# WIDFIELD WSD EL PASO COUNTY, COLORADO GRADING AND EROSION CONTROL PLANS

GRADING AND EROSION CONTROL PLANS  
WIDFIELD WSD  
NORTHERN UPPER E. TO W. TRANSMISSION MAIN  
WATER MAIN REPLACEMENT PROJECT  
EL PASO COUNTY, COLORADO

Issued 09/14/22

♦ EROSION CONTROL PLAN  
STA. 10+00 - 18+50

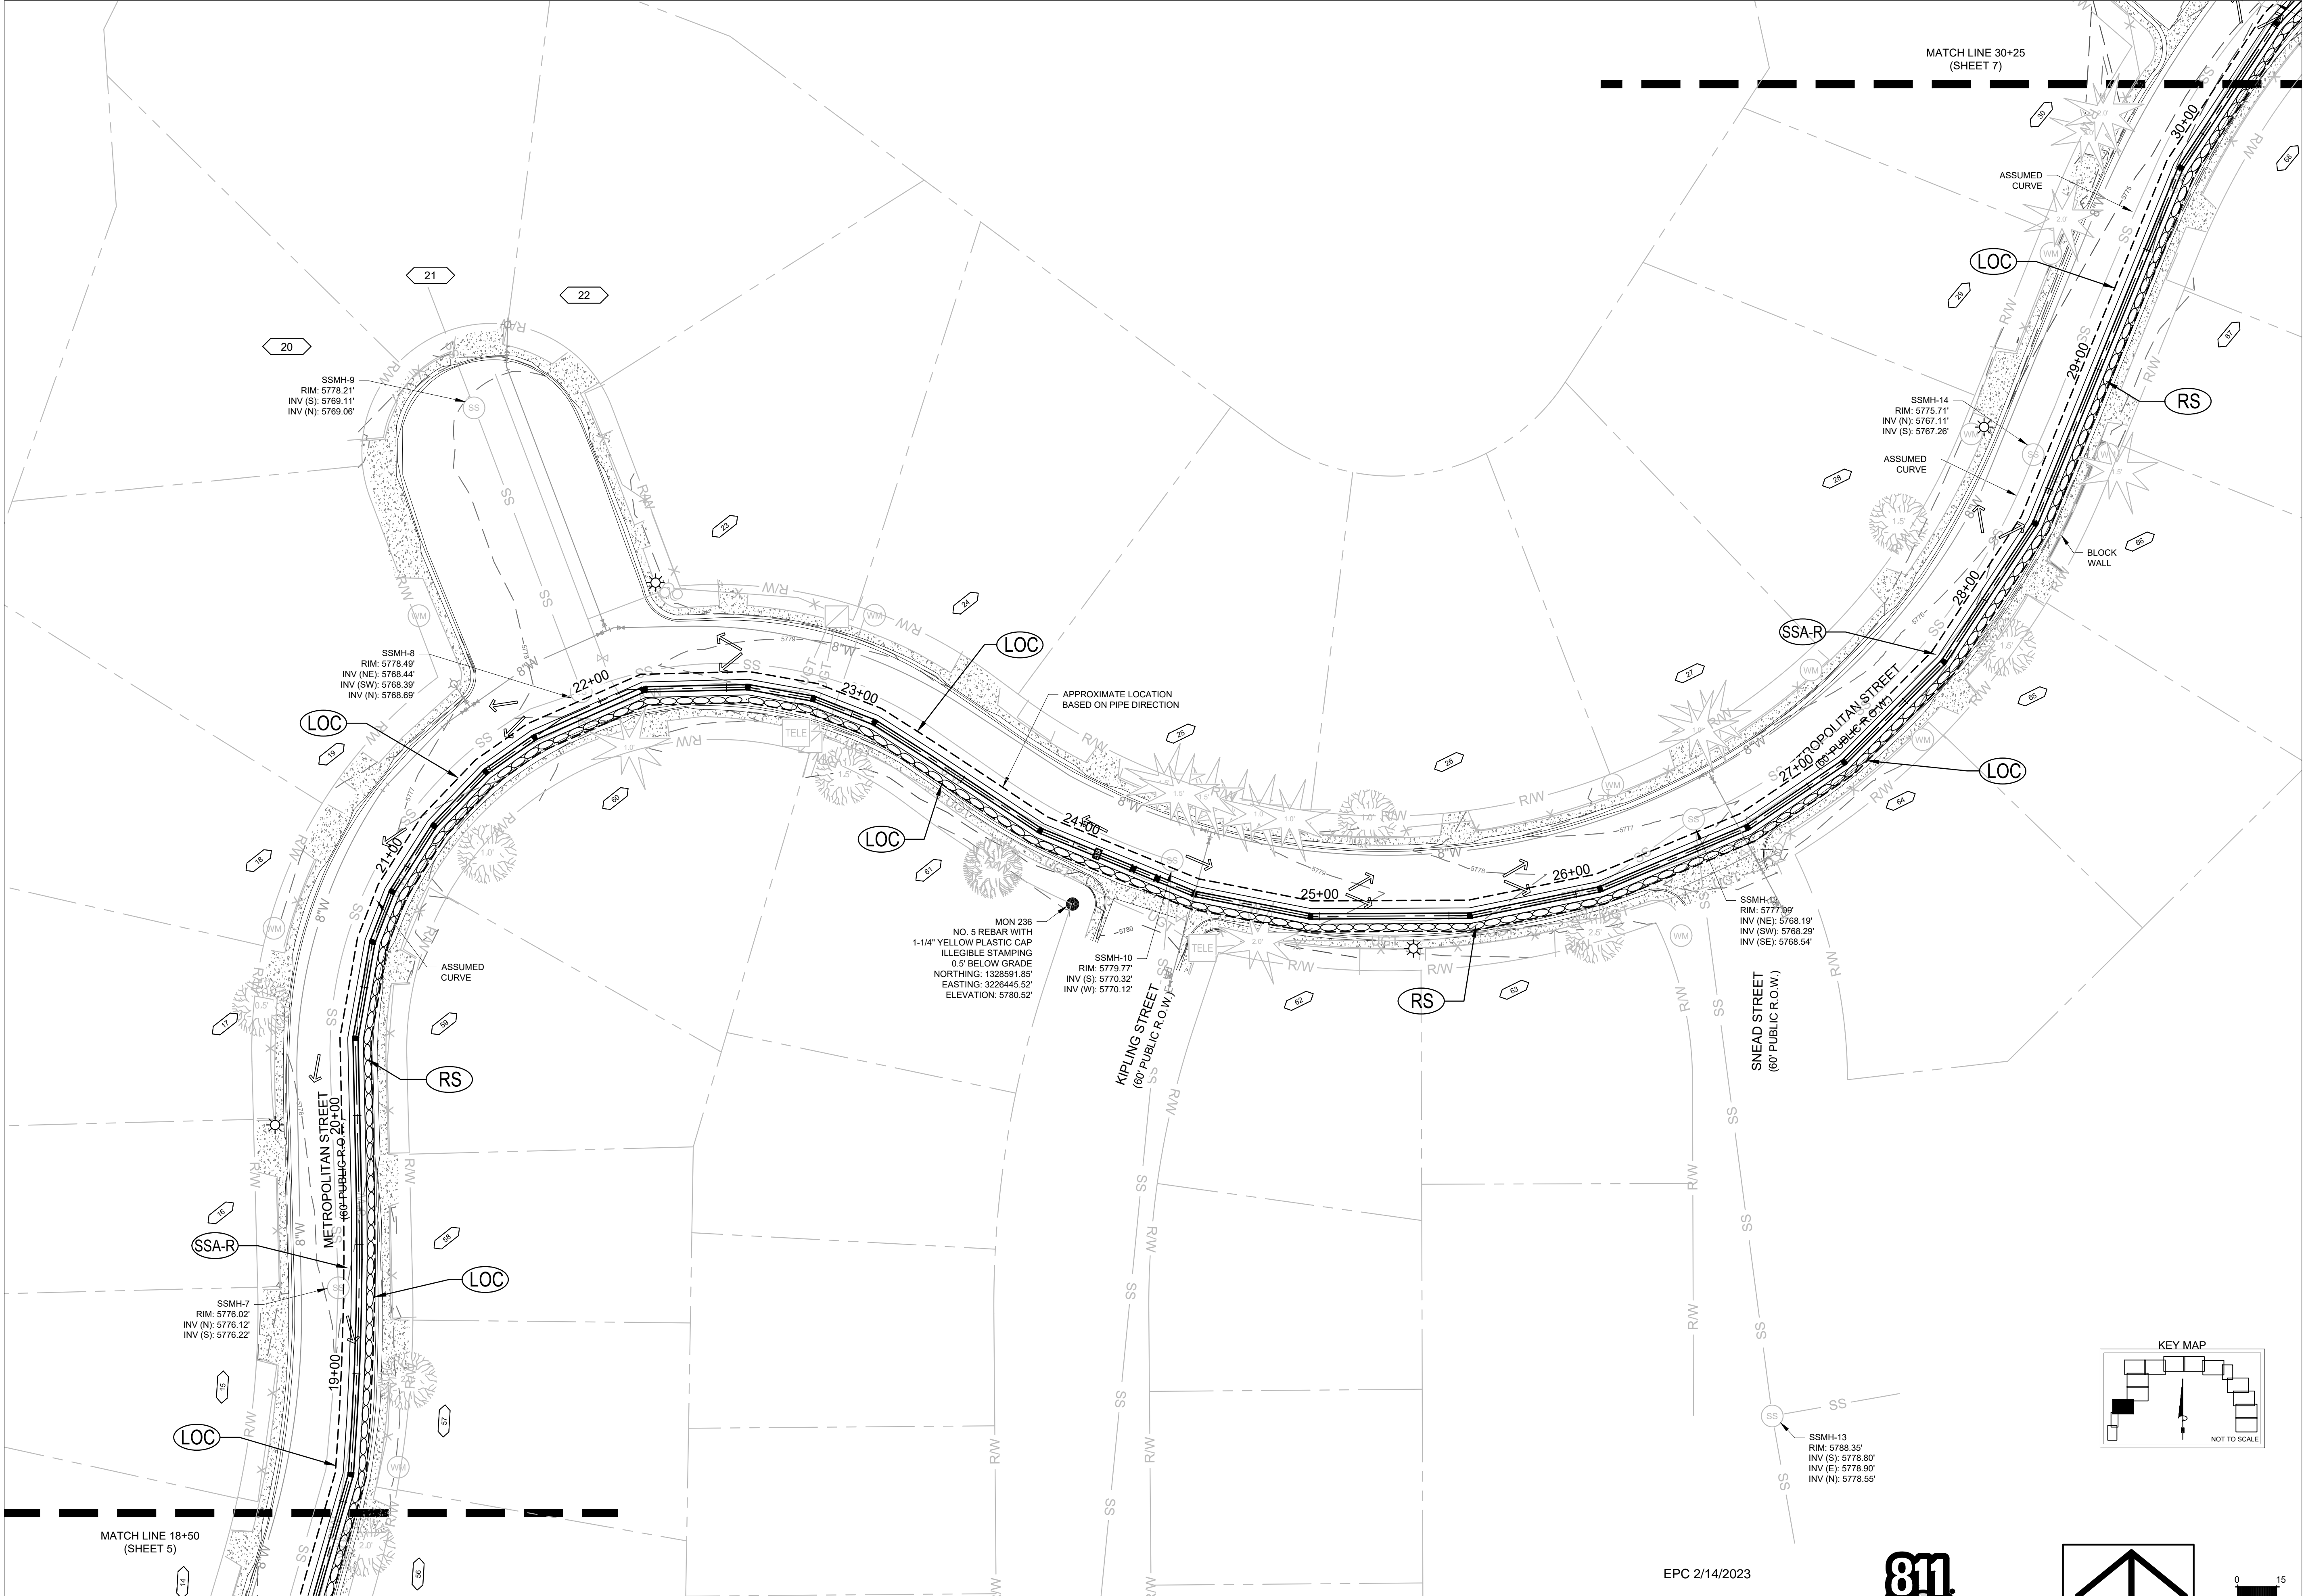
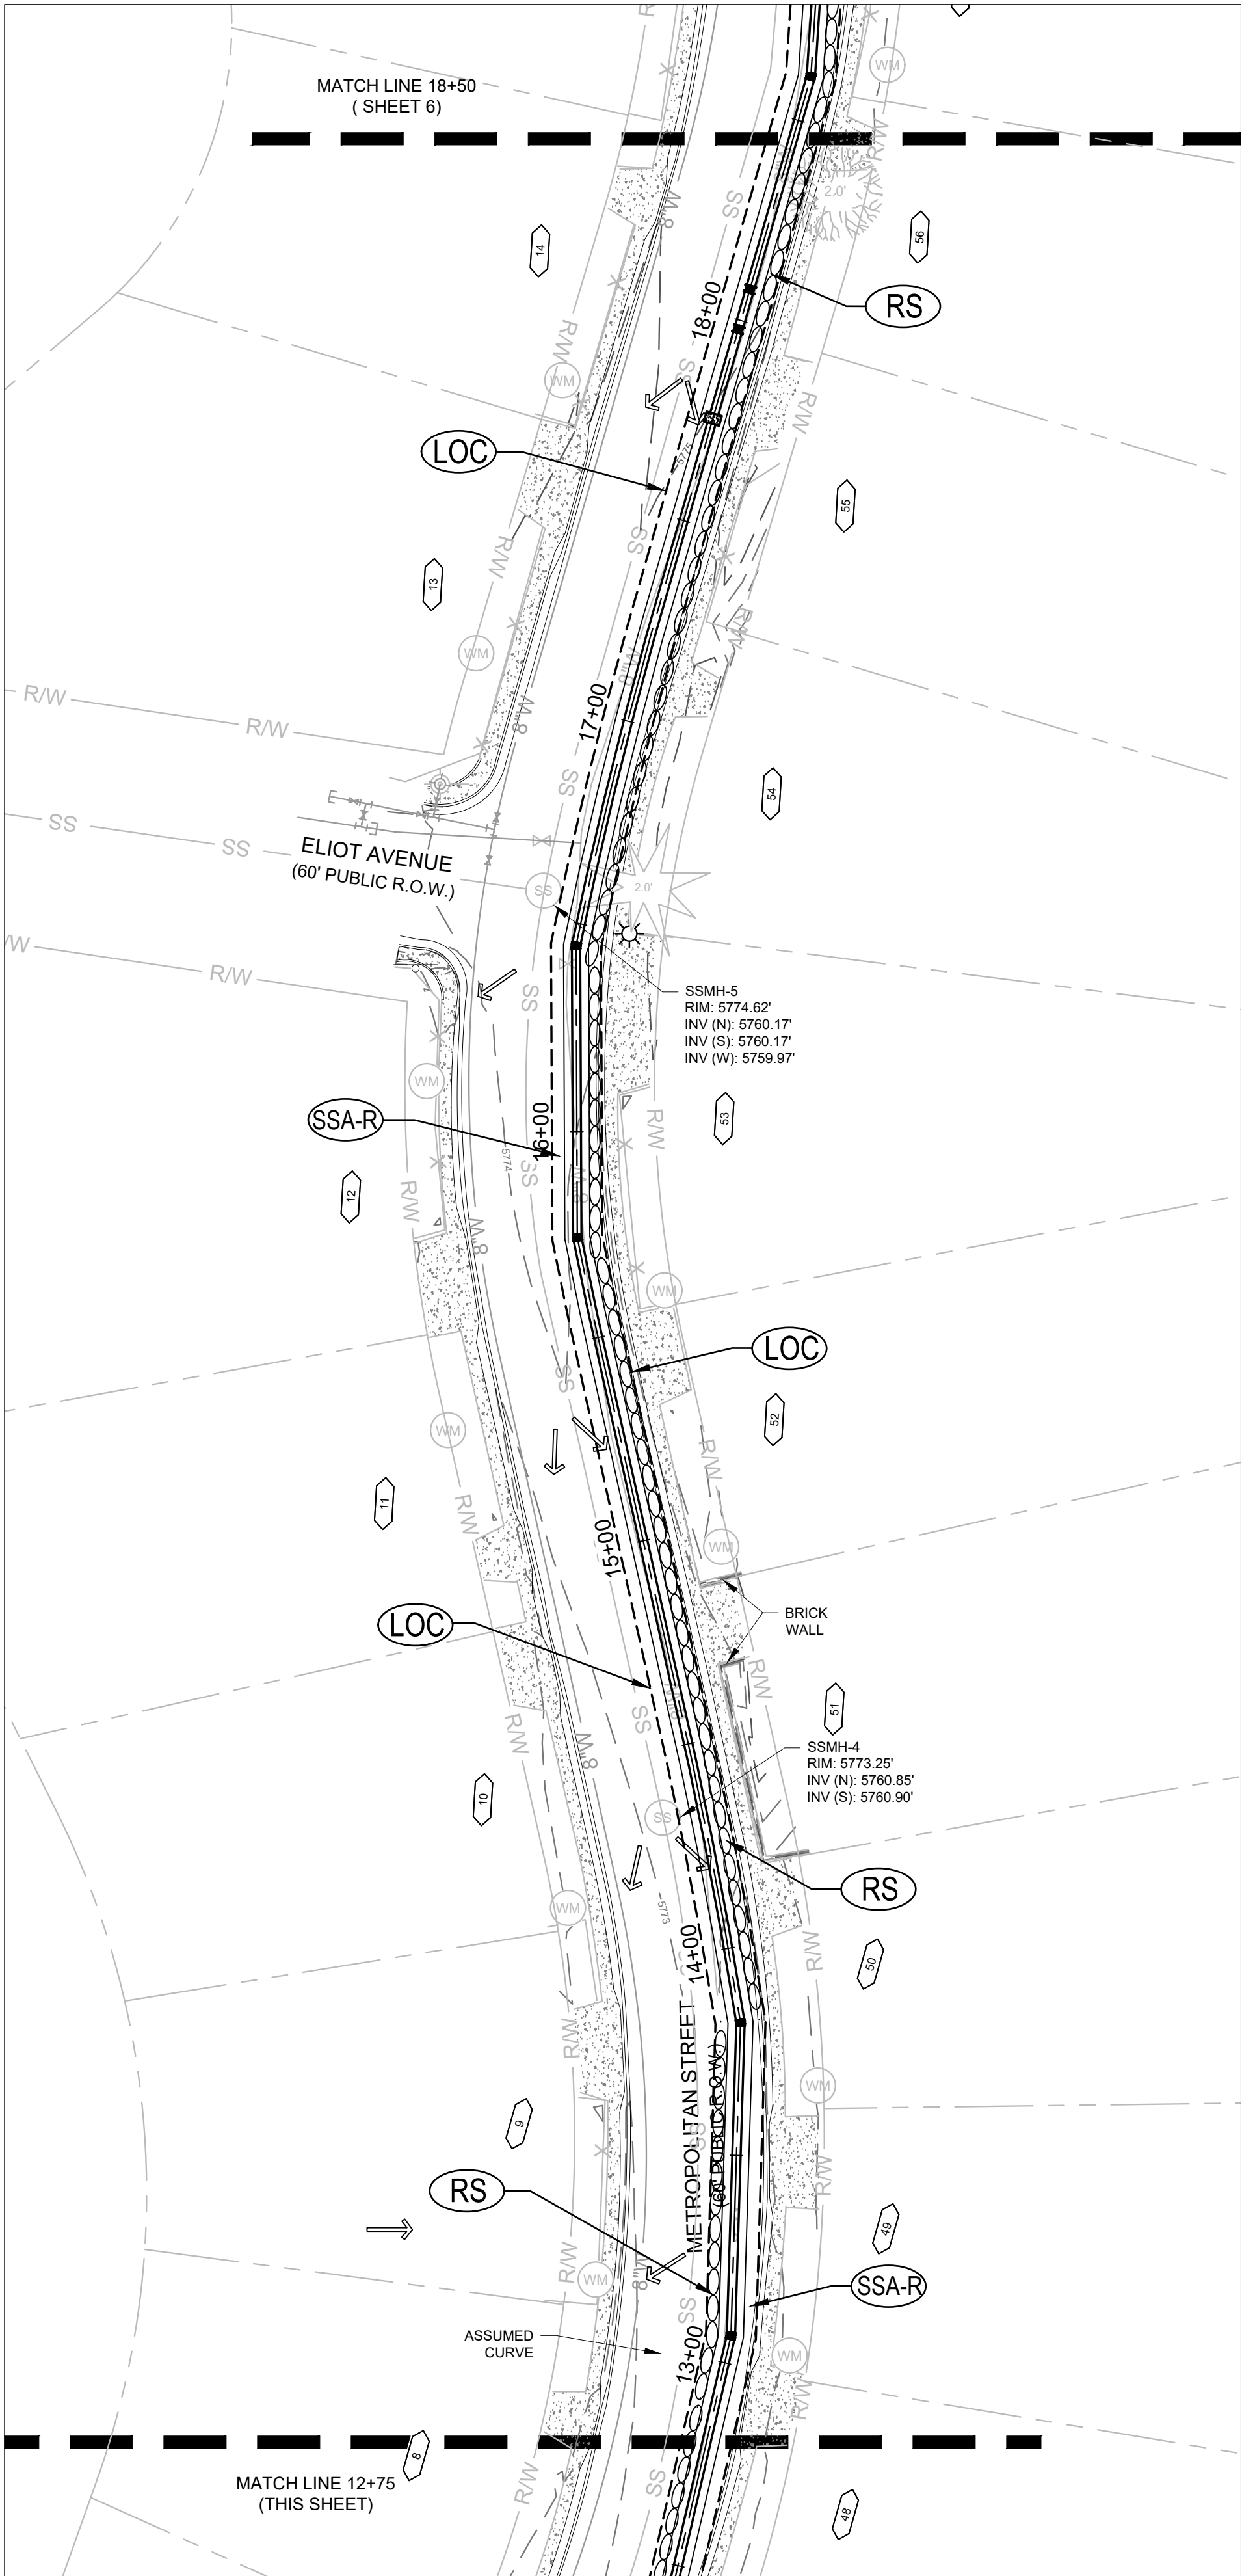
Please show all easements where the proposed waterline is to be in private property on all sheets.
